From: Joanne Lewis <Joanne.Lewis@arun.gov.uk>
Sent: 11 November 2020 14:36
To: Planning.Responses <Planning.Responses@arun.gov.uk>
Subject: RE: Planning Consultation on: Y/97/20/PL

Application No: Y/97/20/PL

Site Address: Kings Close Yapton BN18 0EX

Description of Works: 2 No 3-Bedroom semi-detached, two storey dwellings, car parking, associated landscaping & access to Main Road. This application is in CIL Zone 2 & is CIL Liable.

PROPOSED HOUSE FLOOR PLANS

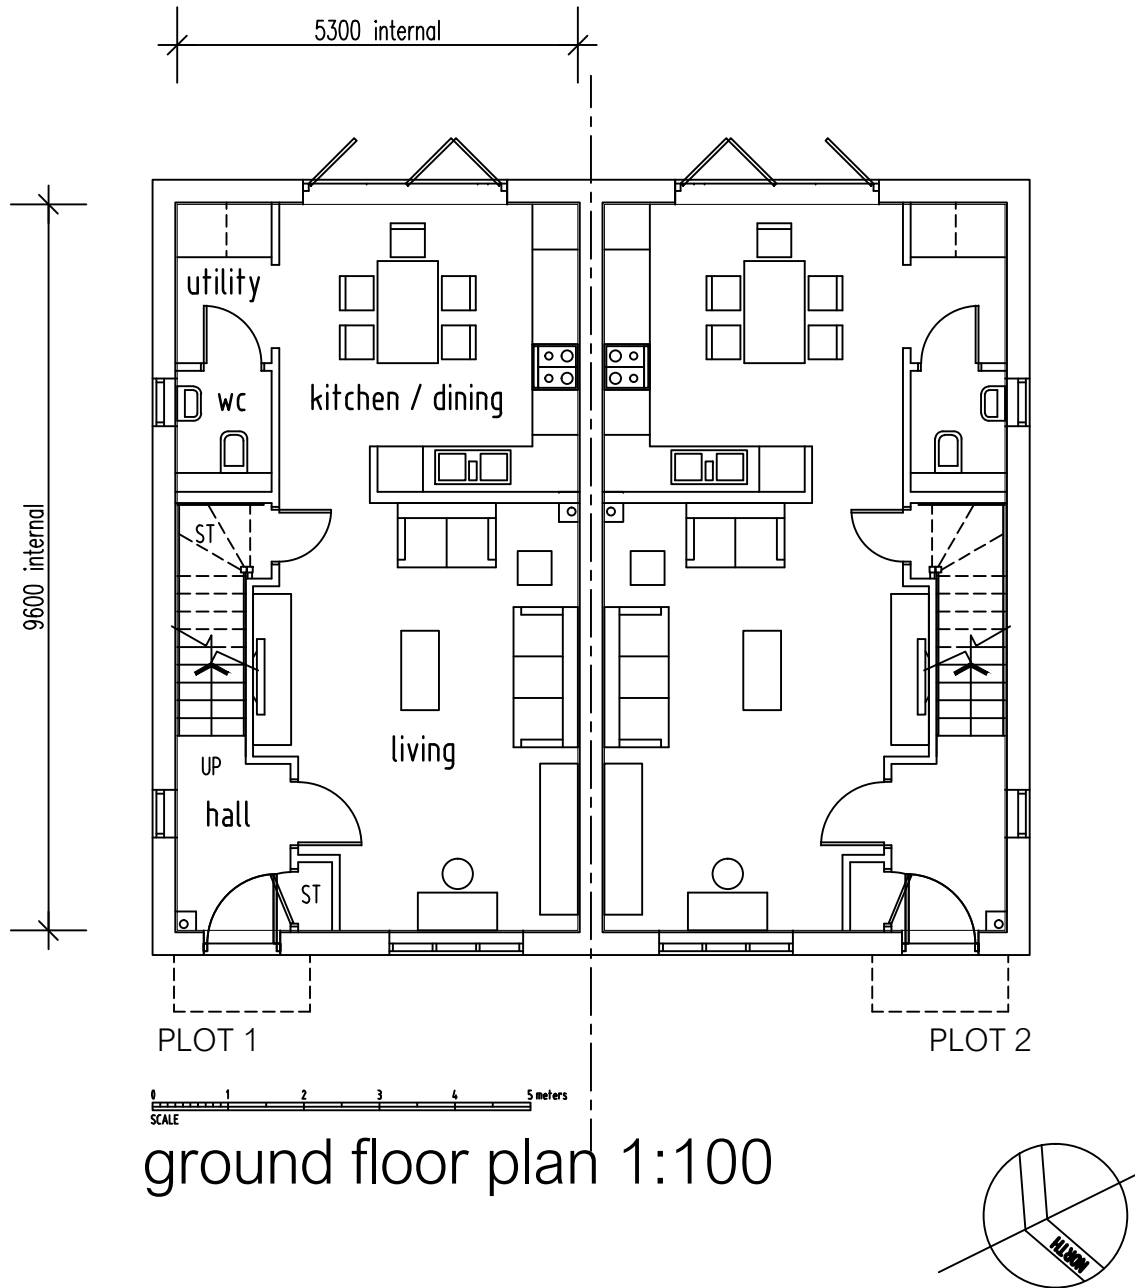
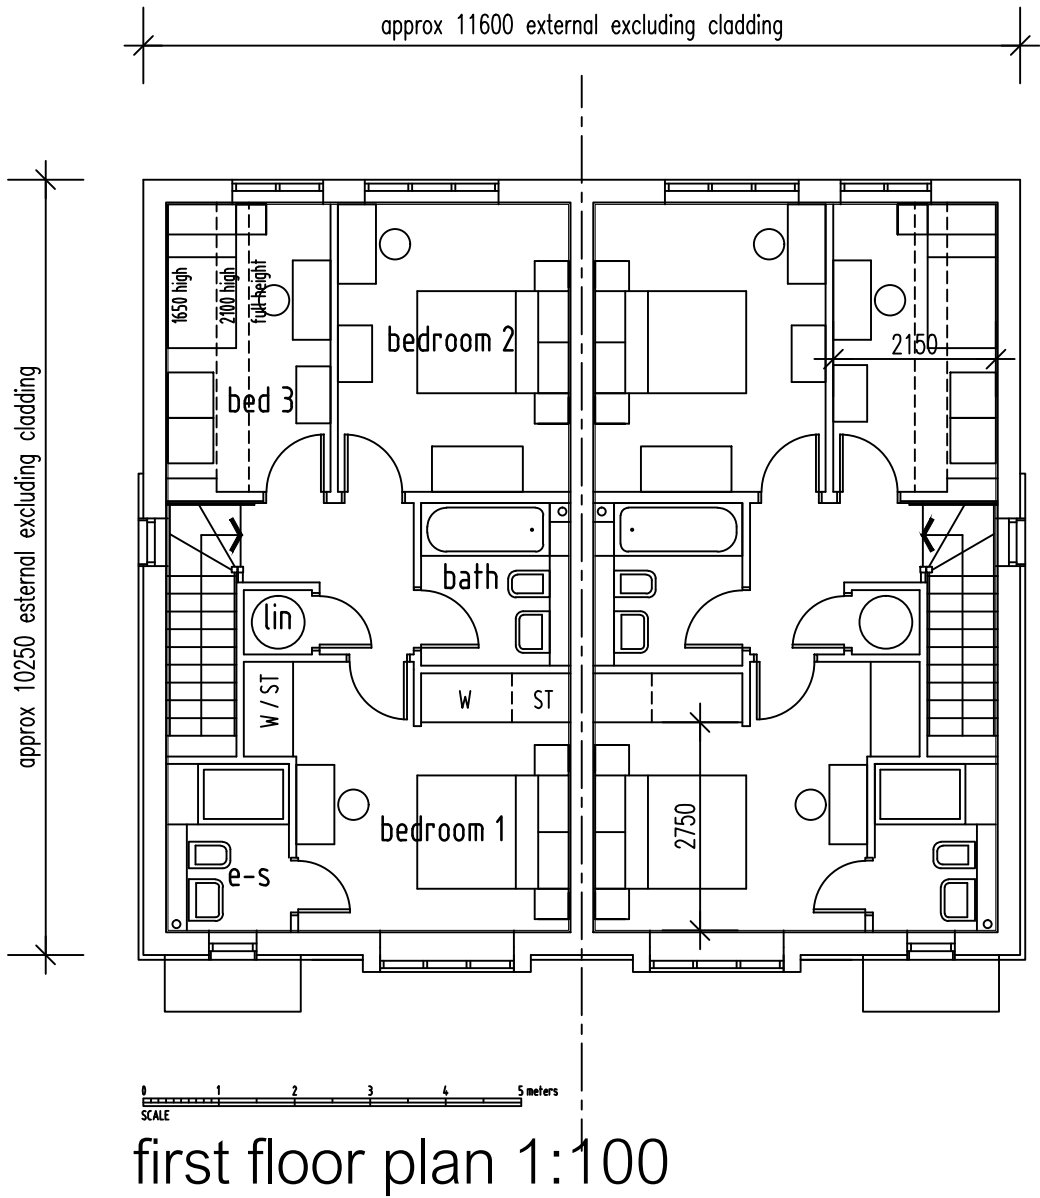
I would recommend that an additional door is added to the utility room to ensure that there is a lobby area between the WC and the kitchen/dining rooms. If this were a commercial kitchen it would not be acceptable to have a WC opening onto a food preparation area in this way and I suggest that this would not be hygienic or popular in a residential property either.
